RE: ENGINEER CERTIFICATION FOR LOT 35 RICHFIELD PARK SUBDIVISION
(C17-D2A26) CERTIFICATION STATEMENT DATED 9/28/98

**RE: RICHFIELD PARK TRACT C-1 (C17-D2A26). GRADING AND DRAINAGE PLAN FOR
PRELIMINARY PLAT AND SITE DEVELOPMENT FOR SUBDIVISION APPROVAL.
ENGINEER'S STAMP DATED JULY 21, 1997.**

**RE: RICHFIELD PARK TRACT C-1 (C17-D2A26). GRADING AND DRAINAGE PLAN FOR
PRELIMINARY PLAT AND SITE DEVELOPMENT FOR SUBDIVISION APPROVAL.
ENGINEER'S STAMP DATED JULY 21, 1997.**

RE: RICHFIELD PARK TRACT C-1 (C17-D2A26). CONCEPTUAL GRADING AND DRAINAGE FOR PRELIMINARY PLAT AND SITE DEVELOPMENT FOR SUBDIVISION APPROVAL. ENGINEER'S STAMP DATED JUNE 30, 1997.

RICHFIELD PARK - TRACT C-1
CONCEPTUAL MASTER GRADING & DRAINAGE PLAN

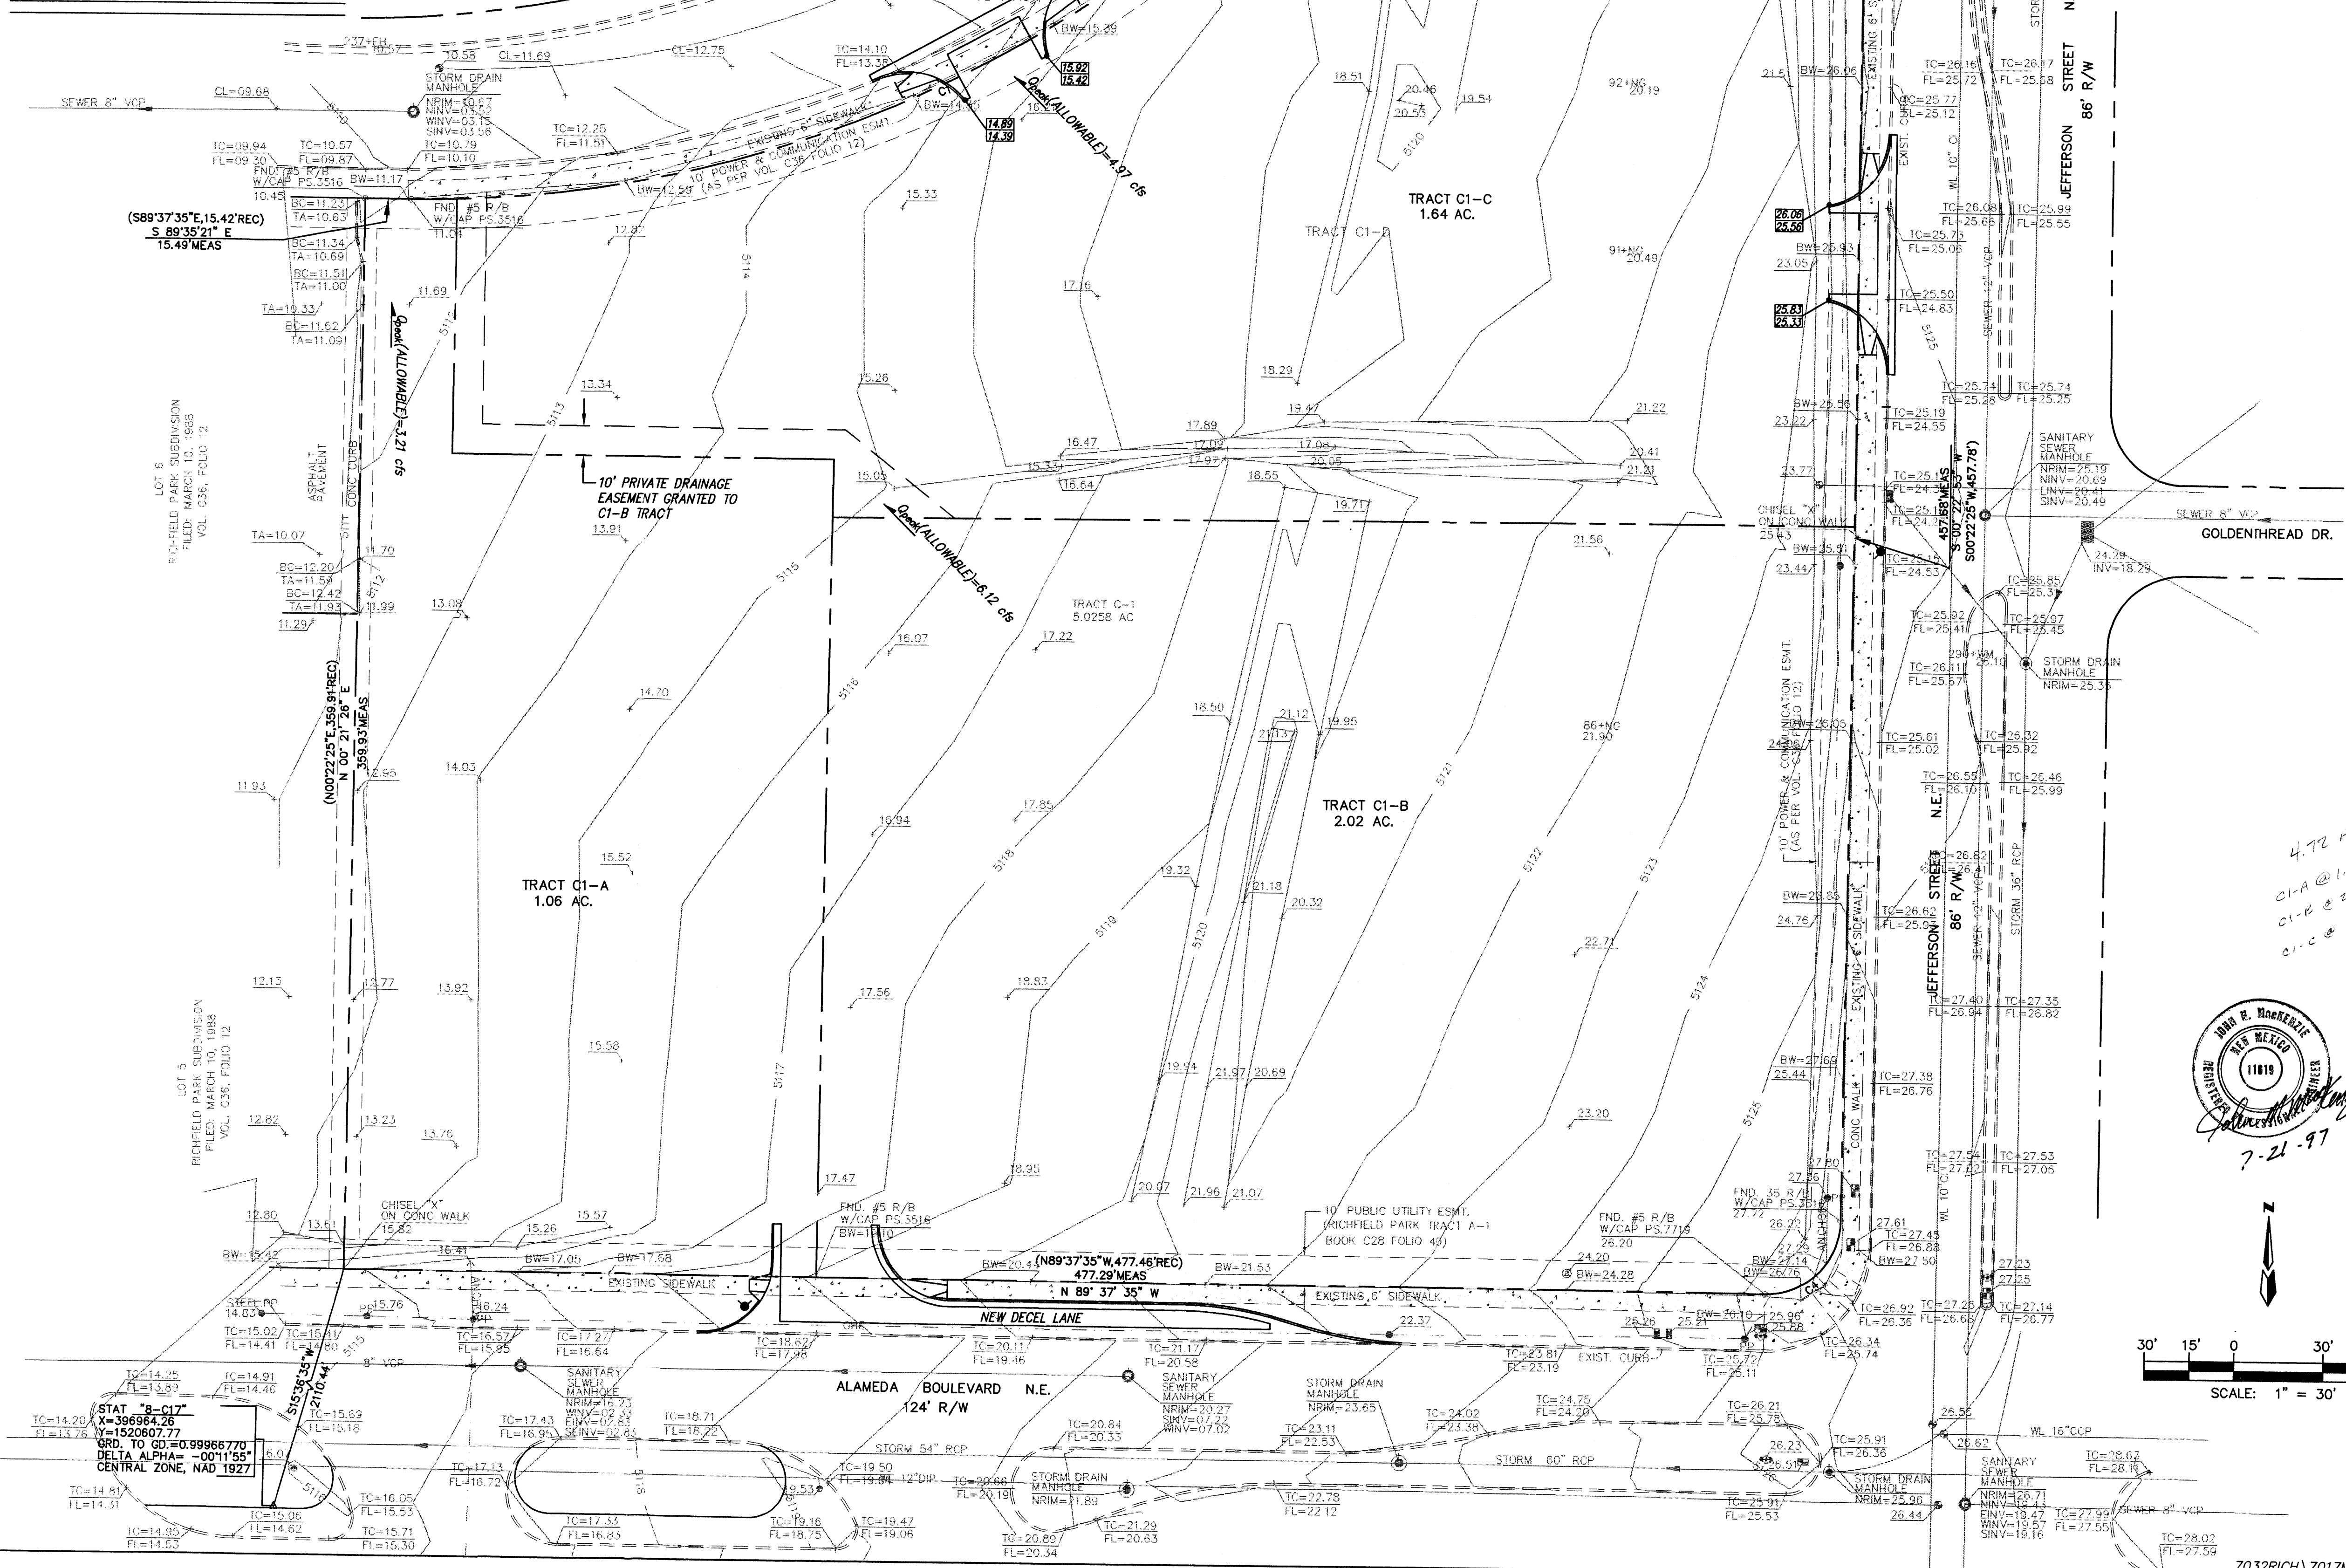
Prior to further approval, please raise the grade at the south end of the drive located adjacent to Jefferson. The flow line grade in Jefferson is 24.83 feet, and the grade at the back of the drive is 24.83 feet.

1. Please supply copies of relevant information from the approved subdivision master plan.
2. Provide an amount of allowable flow in cfs/acre. Using the amount of 69% of peak developed discharge is too ambiguous.
3. If the drainage easement shown on Tract C1-C is to be built for and maintained by Tract C1-C, than the flow from Tract C1-B should not enter the easement.
4. Provide a copy of the current FEMA floodplain vicinity map.
5. Are you proposing to construct the drives now? Provide spot elevations at proposed drives. A 1-foot water block is required.
6. A conceptual grading and drainage plan is not sufficient for preliminary plat approval.
7. Provide all AHYMO calculations for preliminary plat approval.
8. Submit a copy of the proposed plat.

1. Portions of the referenced report by Espey, Huston and Associates (1986) have been copied and attached. Please refer to page 2 of the calculations to find that the peak Q_{100} is 93.7 cfs from the original 31 ac. basin B using "old" hydrology.

2. By allocating areal percentages, the allowable discharge for this basin is 3.03 cfs/ac. Each site's allowable discharge has been revised accordingly.

3. The drainage easement on tract C1-C is to be built and maintained by the owner(s) of tract C1-B. A note has been added to the plan further limiting its usage to tract C1-B.

4. The appropriate portion of the FEMA map has been added to the plan.
5. Let's assume that all driveways are to be constructed now. As shown on the attached portion of the more detailed grading and drainage plan for tract C1-B, there is a 3' water block along Alameda Blvd. For the driveway on Jefferson, please note the flowline elevation 25.12 along the extreme west gutter of southbound Jefferson. From this high point street runoff flows both north and south in the driving lanes. Combined with runoff from the median and the sidewalks along the west side of Jefferson, the area of the drainage basin producing runoff that flows in front of the Jefferson driveway is approximately 6,000 SF, producing a discharge of 0.63 cfs, according to a AHYMO. This barely justifies any water block, but a six inch water block will be constructed as shown.

6. As discussed, I am removing the word conceptual from the title. *I don't see any water block on South side.*
7. All AHYMO calculations are attached hereto.
